KITTITAS COUNTY COMMUNITY DEVELOPMENT SERVICES

Subject: Palomino Fields, Division 8 (LPF-21-00012) Final Long Plat – Staff Review, Return of Application- Additional Information Required.

PALOMINO FIELDS PLAT - DIVISION VIII

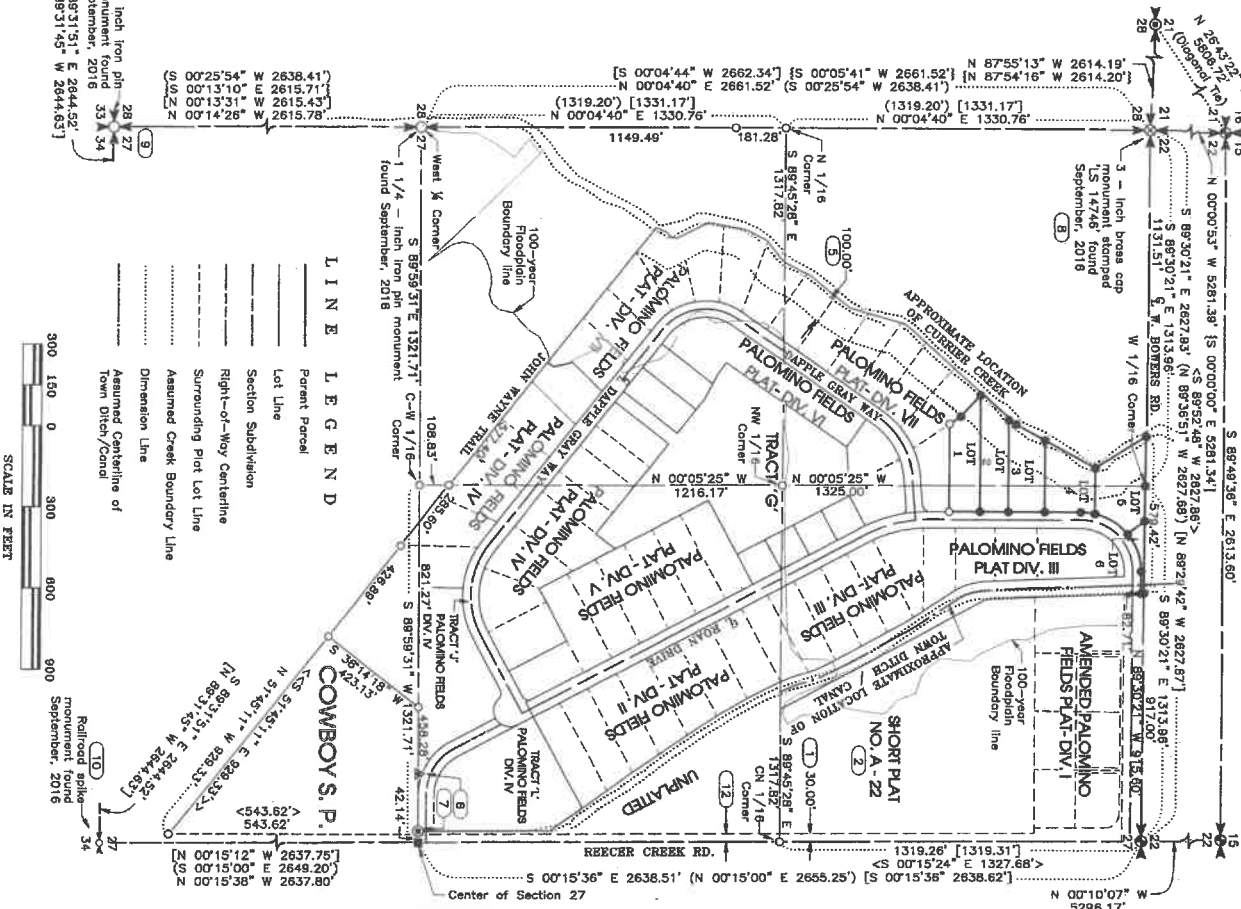
- The final mylars shall note the final plat file number LPF-21-00012 on the face of the plat in addition to the preliminary approval number LP-07-00031.
- Taxes on parcel #961599 must be paid in full before final signature.
